Ribble Valley Borough Council
Church Walk,
Clitheroe,
BB7 2RA

Phone: 0300 123 6780
Email: lhscustomerservice@lancashire.gov.uk
Your ref:
Our ref: LHS/CS/3/2015/0768
Date: 15th October 2015

Proposal:	Demolition of an existing building and the erection of two detached dwellings and annex
Location:	9 Downham Road Chatburn Lancashire BB7 4AU
Grid Ref:	376966 - 444111

Location PLAN

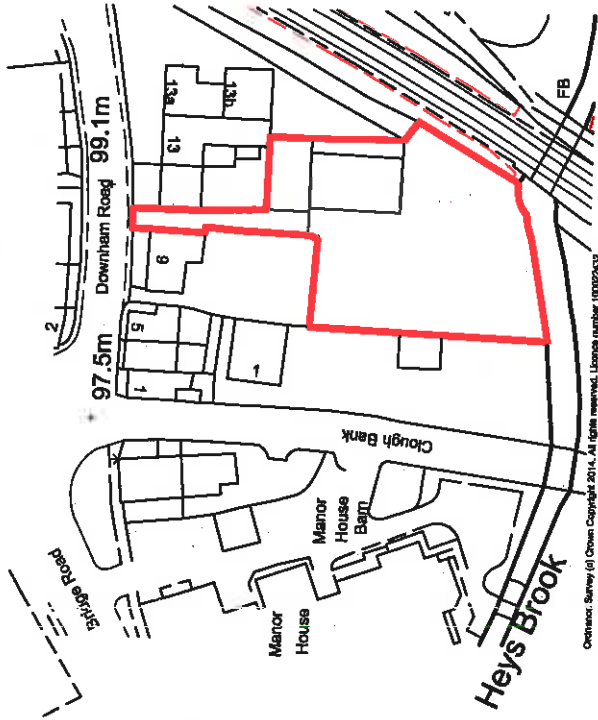
From observations on site and the information provided on the applicant's site location plan the sight line requirement is fully achievable over the applicants land and the existing adopted highway. The main issue is ensuring the sight lines can secured under condition for perpetuity. The proposed new dwellings will generate more car movements and the new property owners would not be able to ensure the sight lines over third party land are maintained.

1. No part of the development shall be commenced until the visibility splays measuring 2.0 metres by 33 metres in both directions to be provided, measured along the centre line of the proposed new road from the continuation of the nearer edge of the existing carriageway of Downham Road, to the satisfaction of the Local Planning Authority. The land within these splays shall be maintained thereafter, free from obstructions such as walls, fences, trees, hedges, shrubs, ground growth or other structures within the splays in excess of 1.0 metre in height above the height at the centre line of the adjacent carriageway.
Reason: To ensure adequate visibility at the street junction or site access in the interest of highway safety in accordance with Quality of Development Policy and Transport Policy in the Local Plan.

SITE PLAN

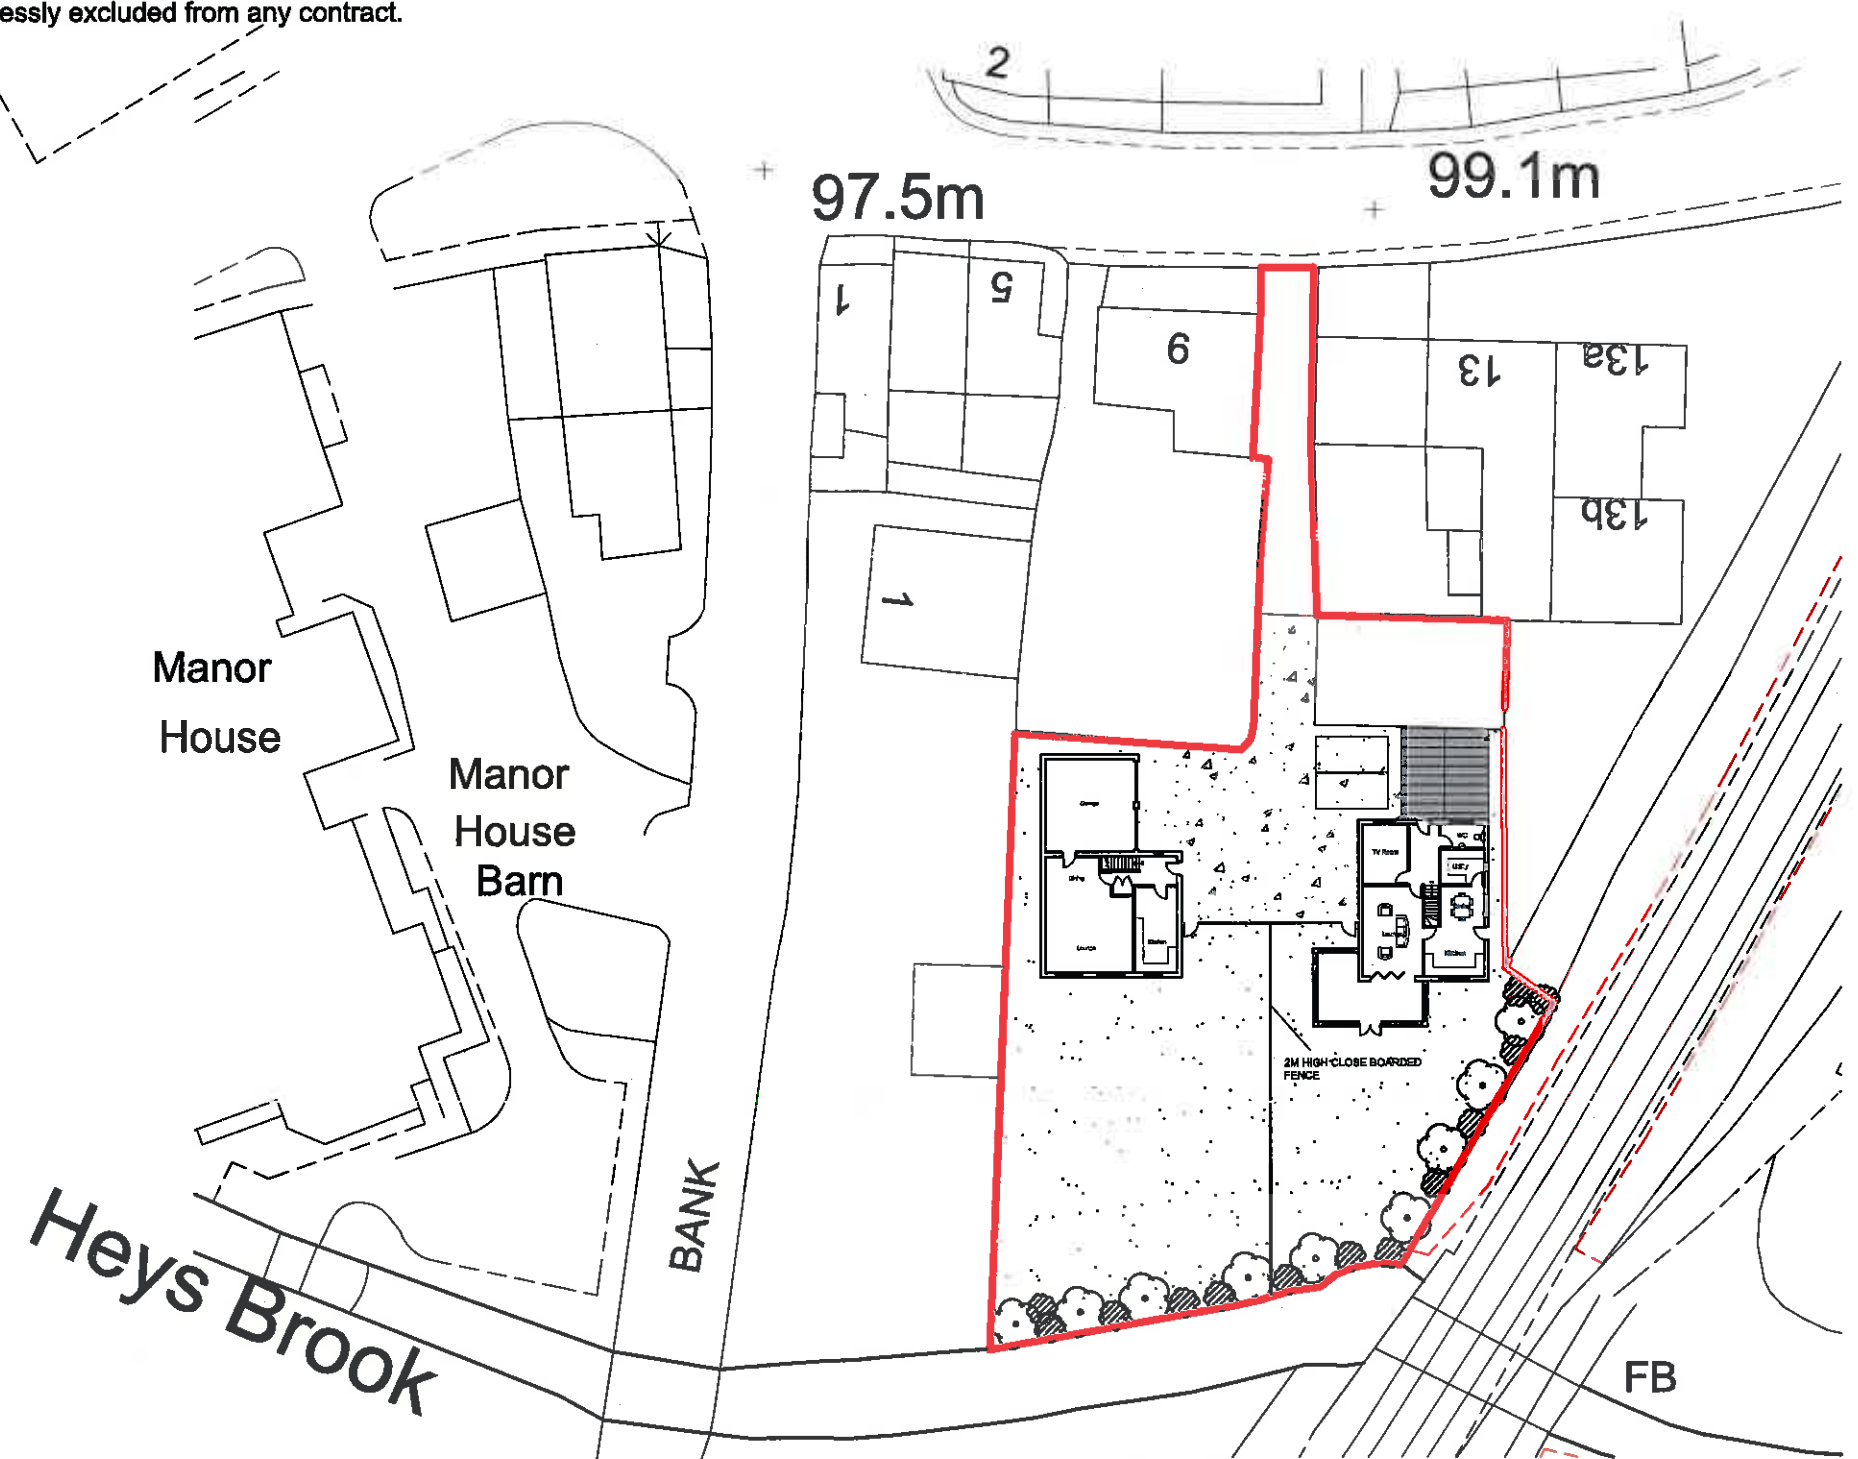
Based on the Joint Lancashire Structure Plan the Highway Development Control Section is of the opinion that the applicant has provided adequate off road parking provision for this type and size of development.

The sight lines of 2.0 x 33m to be provided in both directions from the centre of the site access onto Downham Road. The site line requirement is based on table 7.1 from Manual for Streets and an estimated wet road 85th percentile speed of 25 mph.

2. The car parking and manoeuvring scheme to be marked out in accordance with the approved plan, before the use of the premises hereby permitted becomes operative and permanently maintained thereafter. Reason: To allow for the effective use of the parking areas.
